**KIRKLEES METROPOLITAN COUNCIL  
INVESTMENT & REGENERATION SERVICE**

Reference No:	<b>2025/62/91884/W</b>
Site Address:	20, Slack Lane, Outlane, Huddersfield, HD3 3FQ
Description:	Erection of single storey rear extension
Recommending Officer:	Joshua Merriman

## **Officer Report – 2025/91884**

Drawing
**Proposed Ground Floor Plan,
Elevations & Site Plan**

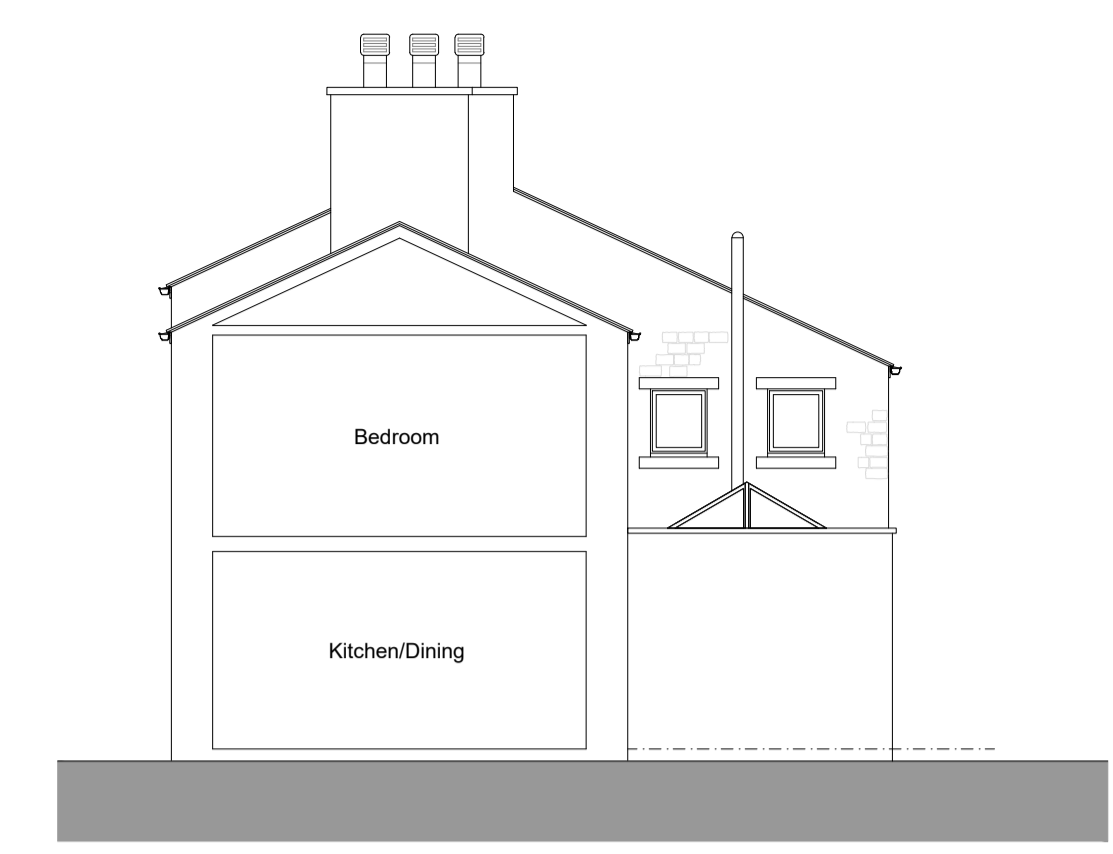
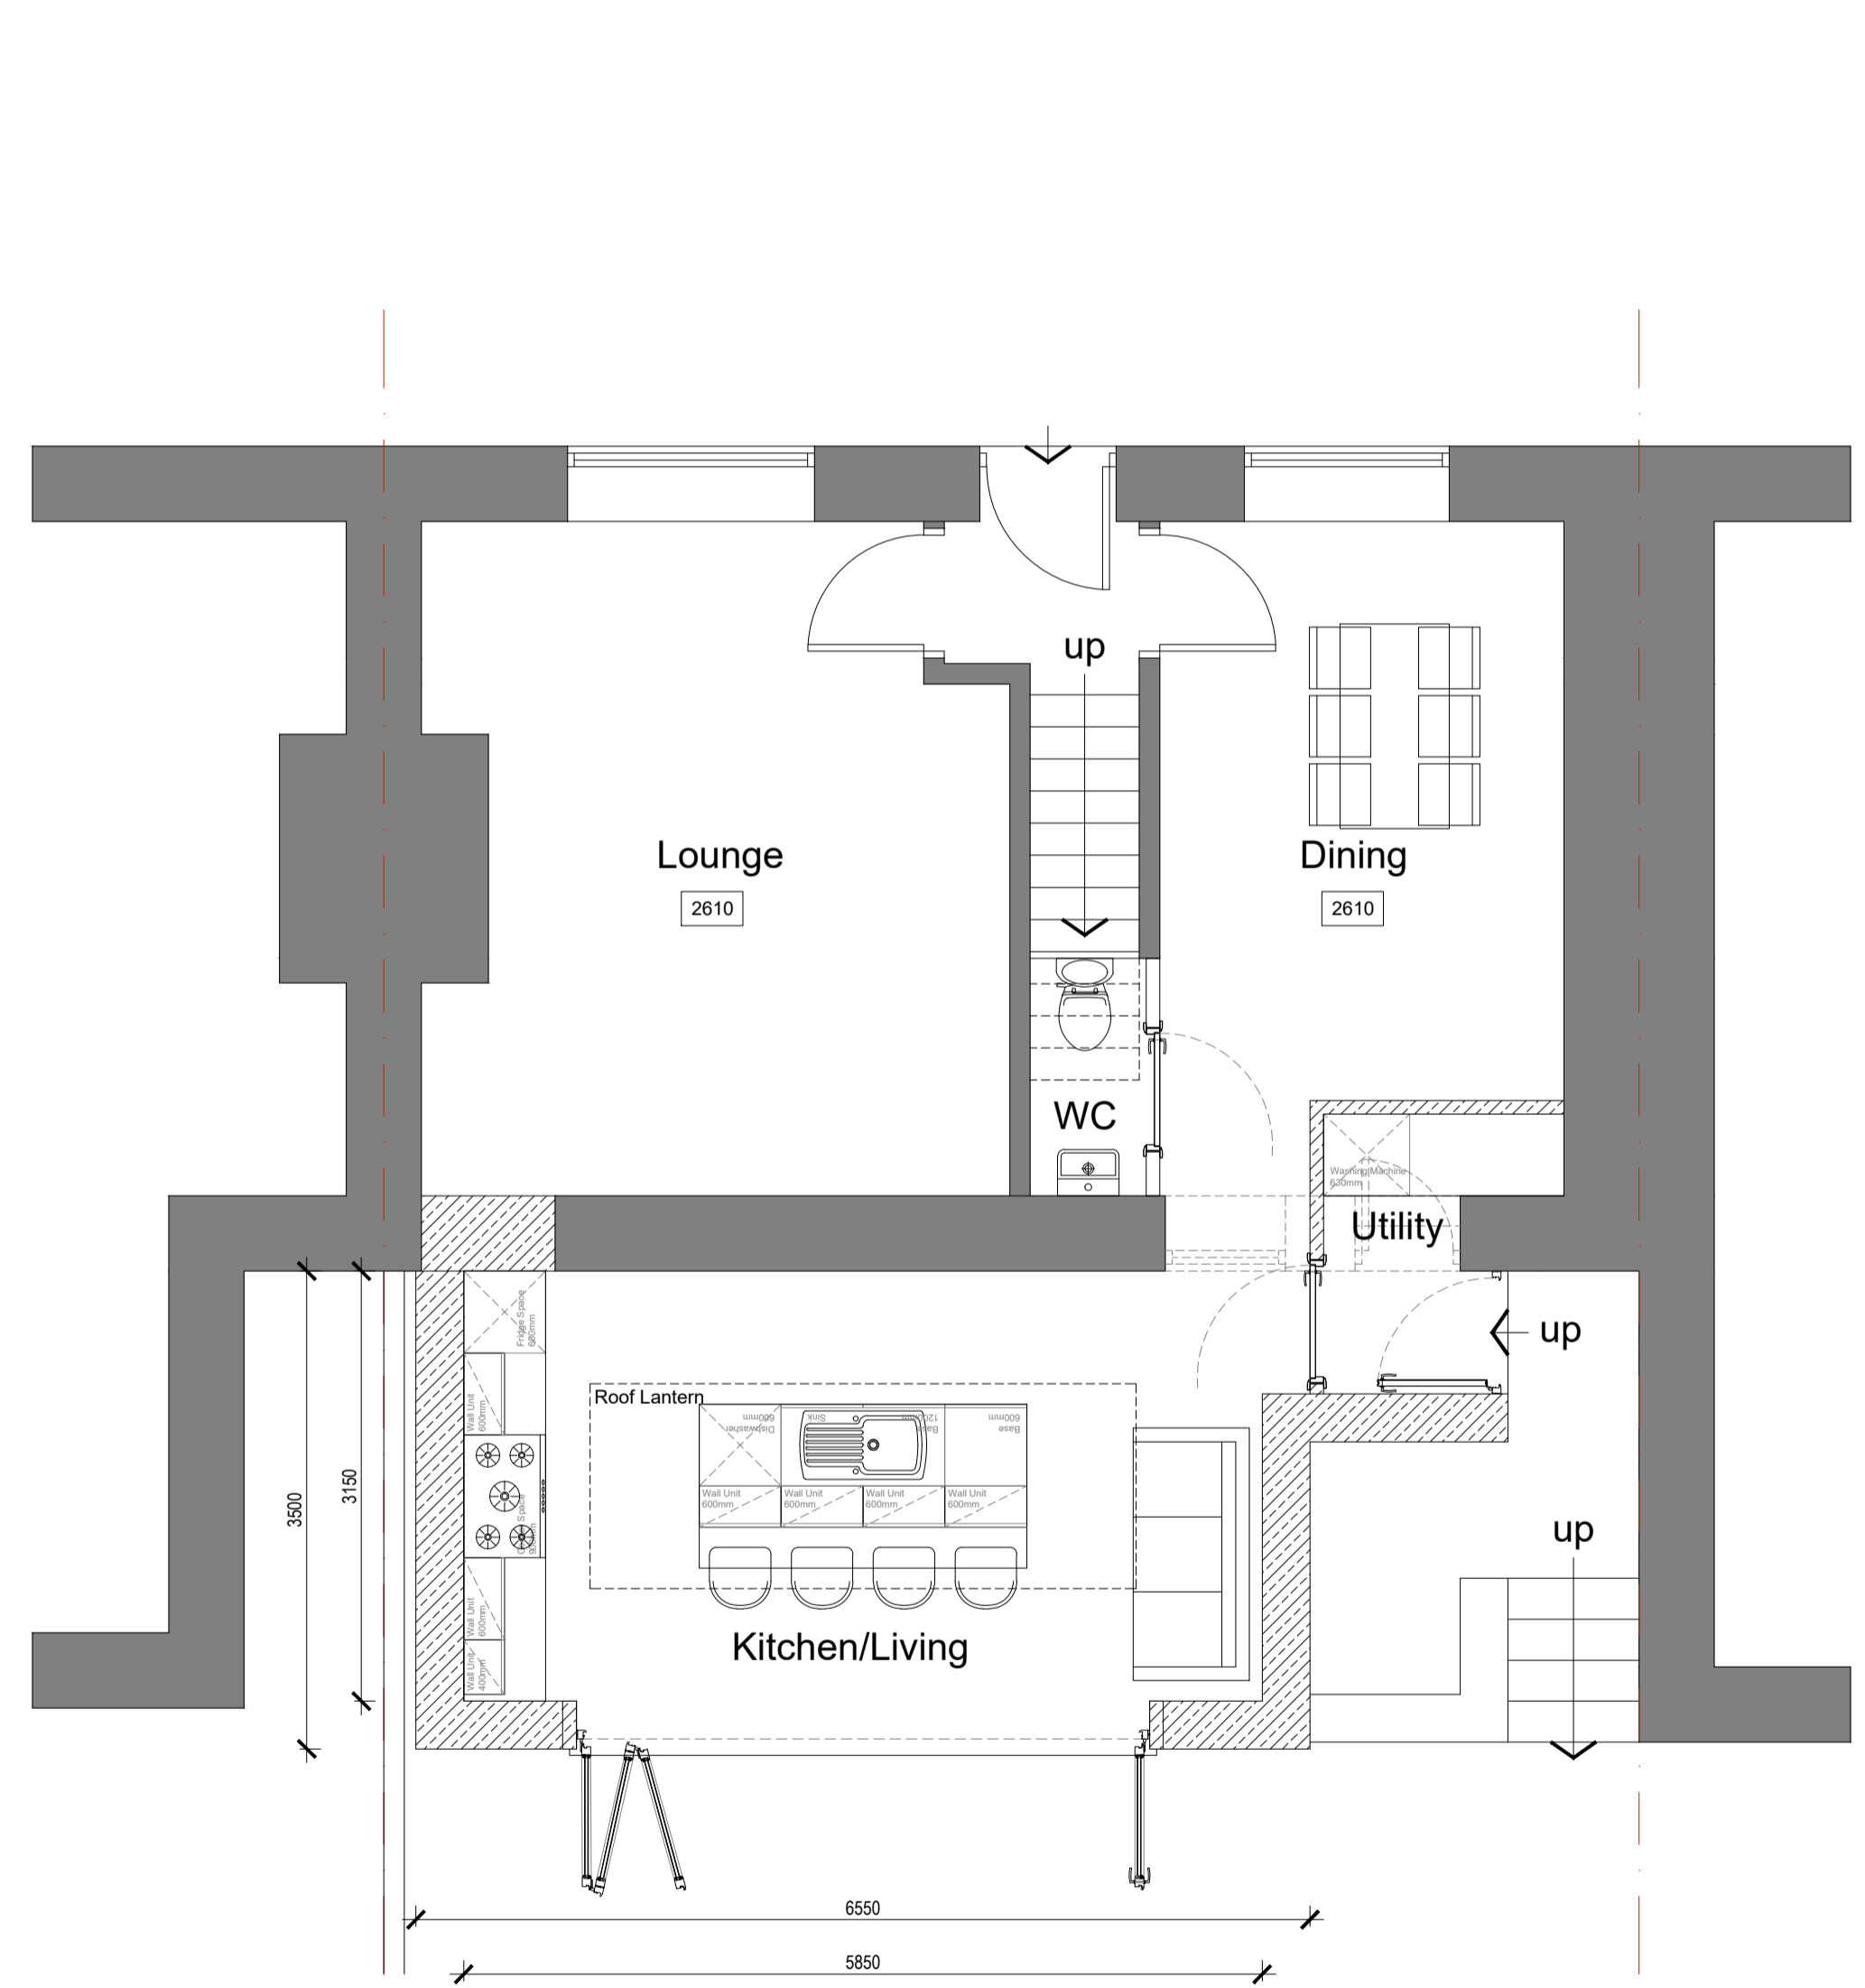
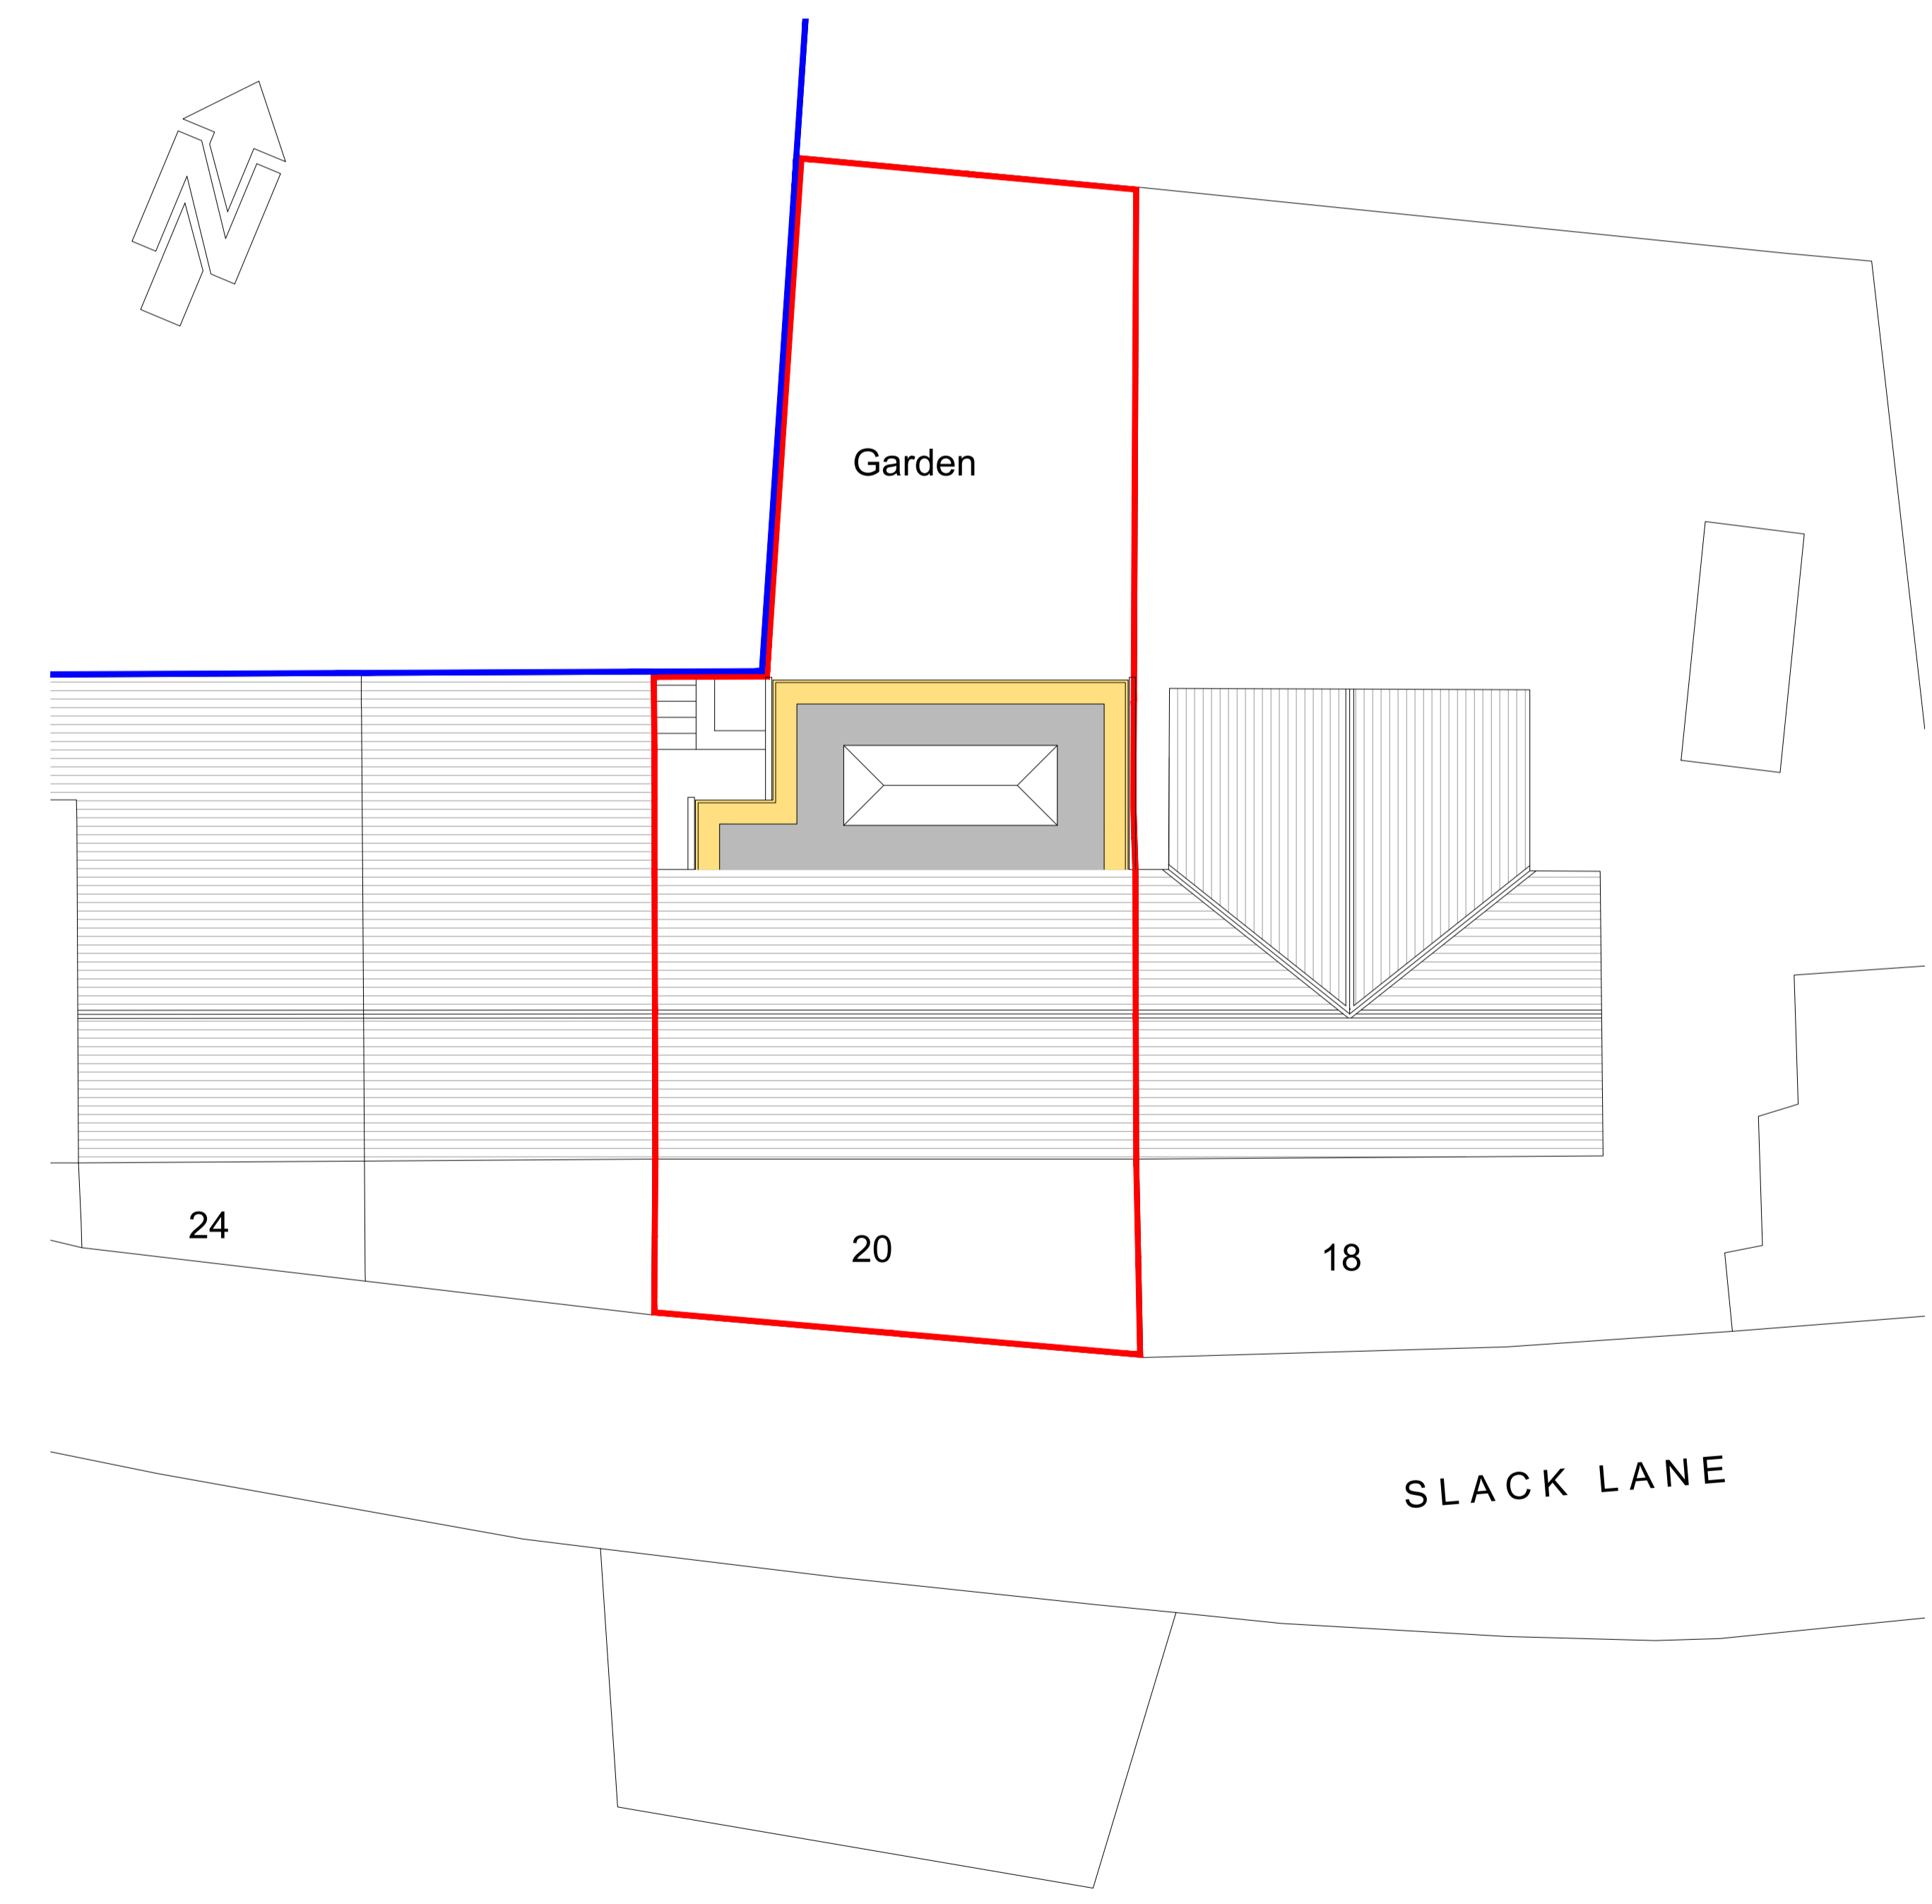
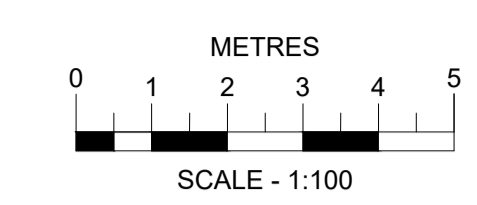
The submitted application form sets out the materials of construction would be an off white render, the design of the proposal has changed in terms of the roof when compared to the previously approved scheme. The proposal would be a parapet wall with flat roof behind and roof lantern in the centre. The proposed roof is considered to be acceptable in relation to the dwelling and would not have a significant visual impact having regard to the parapet roof design and use of matching materials given the host use of render to the host / neighbouring dwellings.

Despite the proposal extending 3.5m from the rear elevation of the original building, where the SPD recommends 3m, exceeding a 2.5m eaves height where it extends over 3m, and being located closer than 1m to the property boundary. It is considered that these would not have a significant impact to the residential amenity of neighbouring properties due to the existing rear extensions erected at adjoined properties.

To ensure the development has an acceptable appearance a condition is recommended to be included which requires the render to be completed prior to the development being brought into use and in accordance with the details of the render set out in the application form which specifies the render would be 'silicone render' in an off white colour finish.
